**Planning Application Ref:** BE/7/18/TC

**Location:** Walnut Tree Cottage, Shripney Lane, Bognor Regis

**Description of works:** Reduce crown to 1No. Weeping Willow by 5 metres, remove one low limb on west side & cut lower branches overhanging footpath

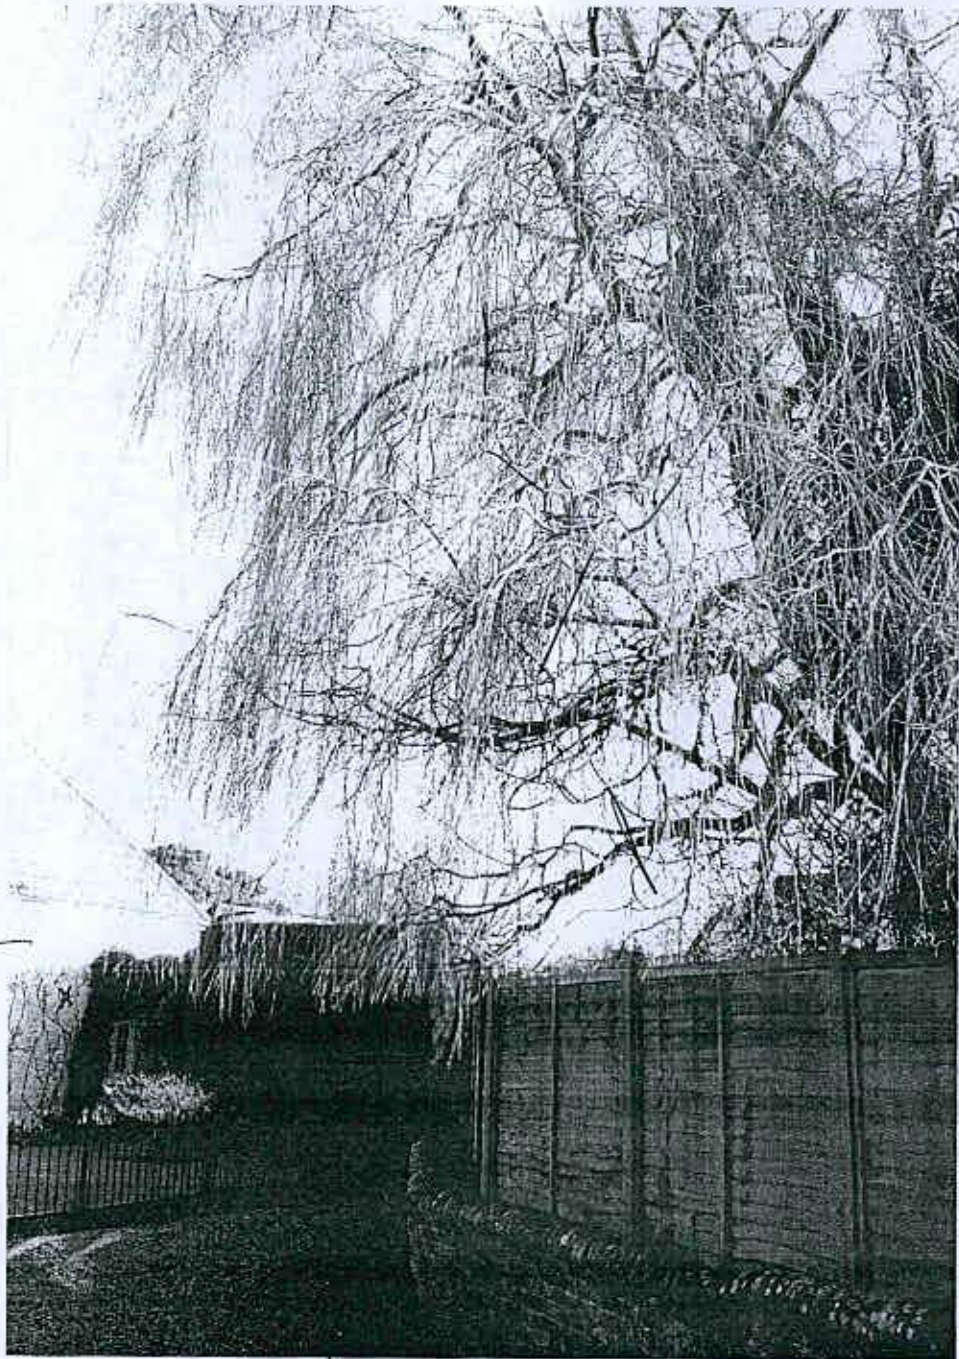
- Tree occupies a prominent position relative to neighbouring cottages but with limited view from the adjacent lane. A long-established ornamental feature tree no doubt appreciated by passers-by and local residents.
- To some extent it is a shame that this tree has received modification to its branch framework. As healthy trees of this type will do, it has responded with vigour to the heavy crown reduction work (more of a pollard-type operation), undertaken c2003. Repeating this operation is now necessary to limit the risk of branch failure.
- Appears to be in good physiological condition, especially for its age. I did not have a close view of the stem base, so cannot comment on its overall structural condition, but there are clearly some cavities in the limb framework – notably on the large west tending scaffold limb, which are a valid concern.

- This is an important feature tree, albeit for a relatively small number of people and its age needs to be considered if it is to not endure unnecessary adverse effect on its health from the work proposed.
- If the tree is pruned to a high standard with respect to previous pruning cuts then what is proposed will be an entirely reasonable operation to carry out at the correct time of year (Mid-winter or mid-summer: avoid Spring and Autumn).
- The risk of tree decline is unfortunately out-weighted by the need to address structural defects in the limb framework.

- I raise **No Objection** to the works that have been applied for and see no reason to make a TPO in this instance.

- Remove small branches to just beyond position of past pruning cuts in order to ensure a satisfactory standard of tree surgery, in the interests of tree health and ongoing vitality.
